8 Soils and agriculture

Cobbora Coal Project - Preferred Project Report and Response to Submissions

**FIGURE 4.1**

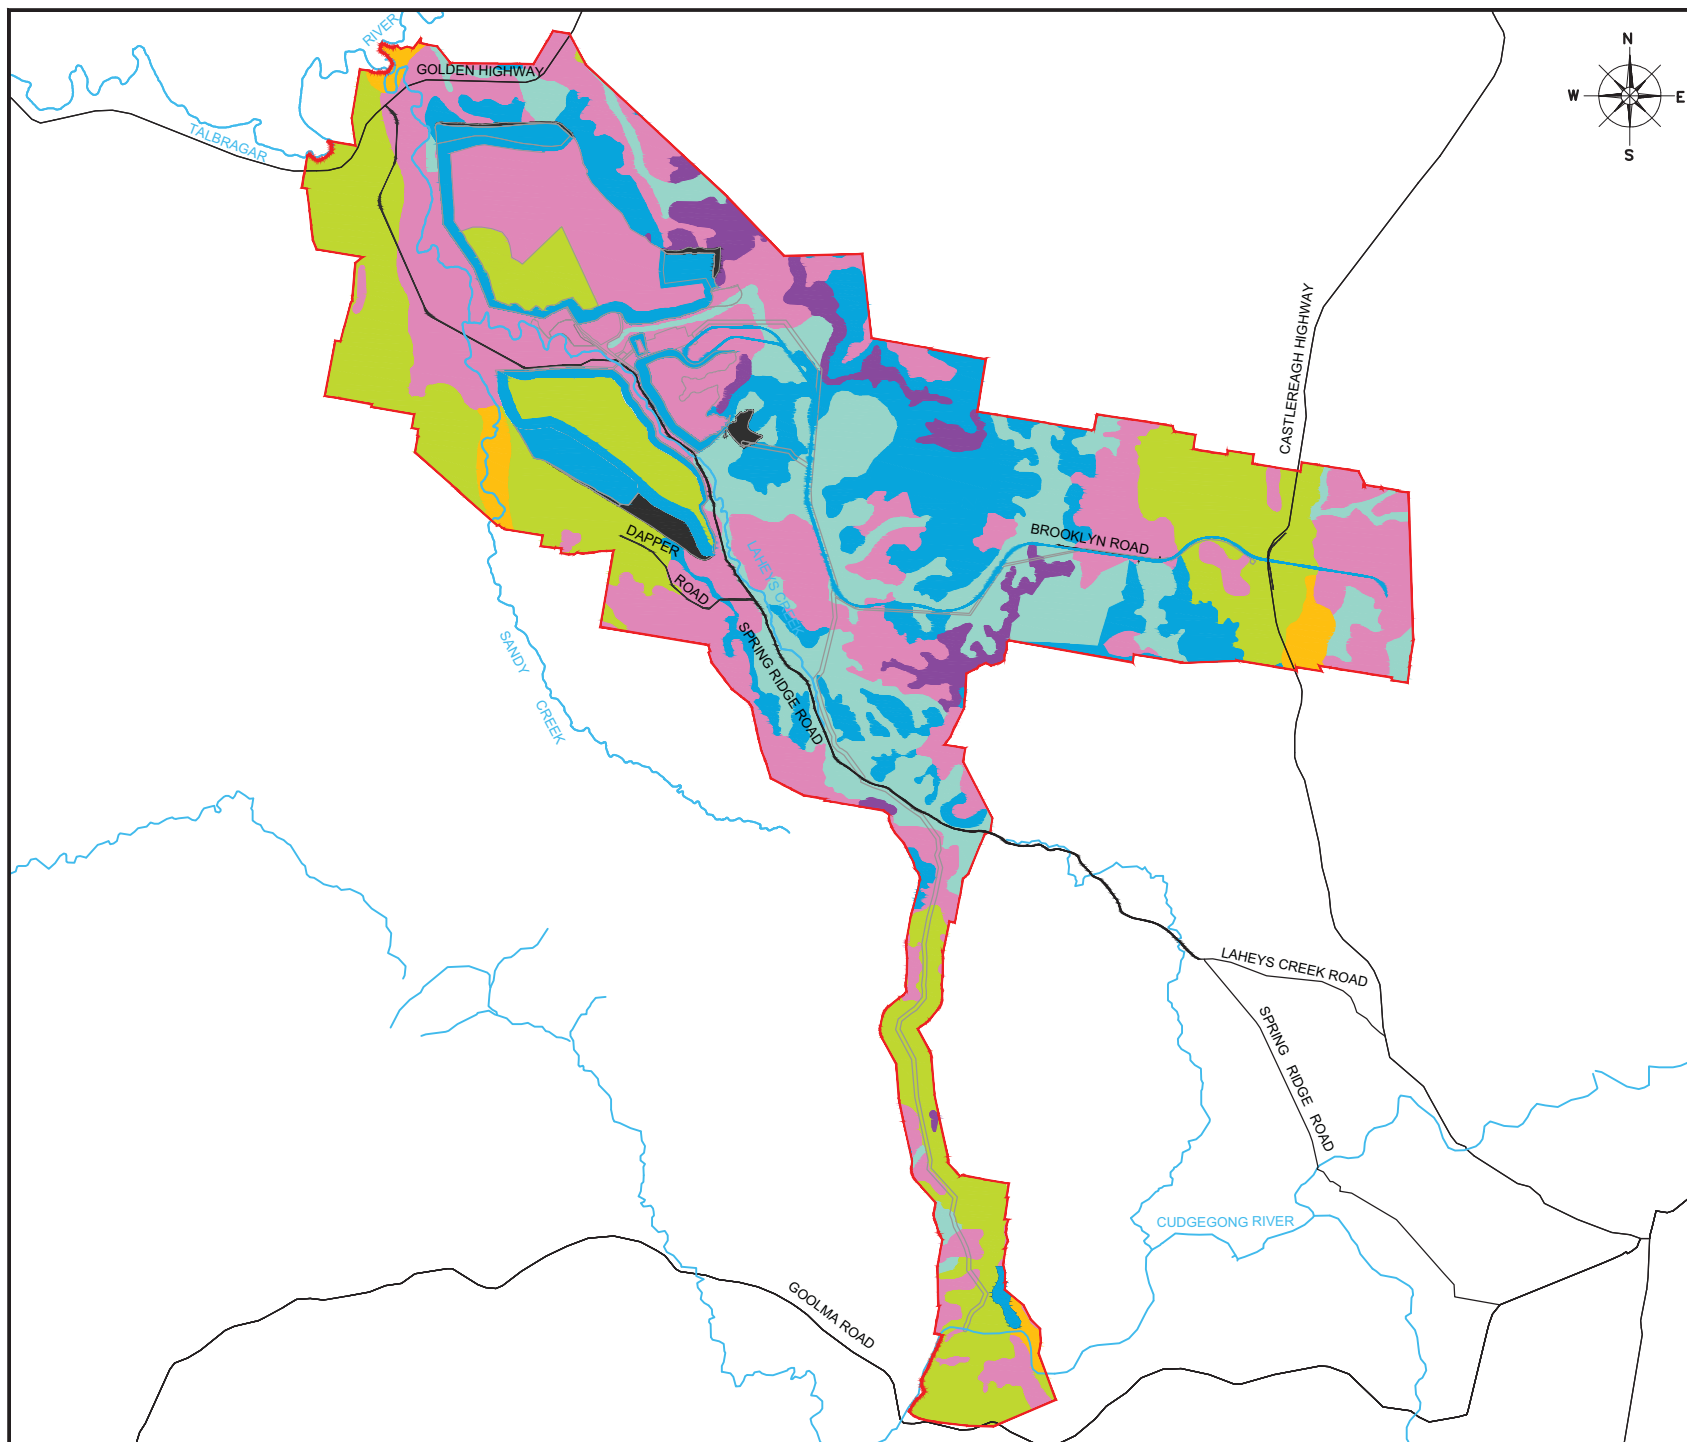
The DP&I comments there is insufficient detail or commitments about final slopes on batters within the mining operations domain. The slopes appear to be generally >10° slopes on outside batters (EA Appendix F, Figure 4.1 indicates 10–18° or 32–56° slopes).

Figure 4.1 shows the slope as a percentage rather than in degrees (a 10° slope is the same as a slope of about 18%). Most of the batters will have a slope of 10 to 20%. Appendix G provides an updated figure (Figure 4.1) showing the slopes in the final landform is provided.
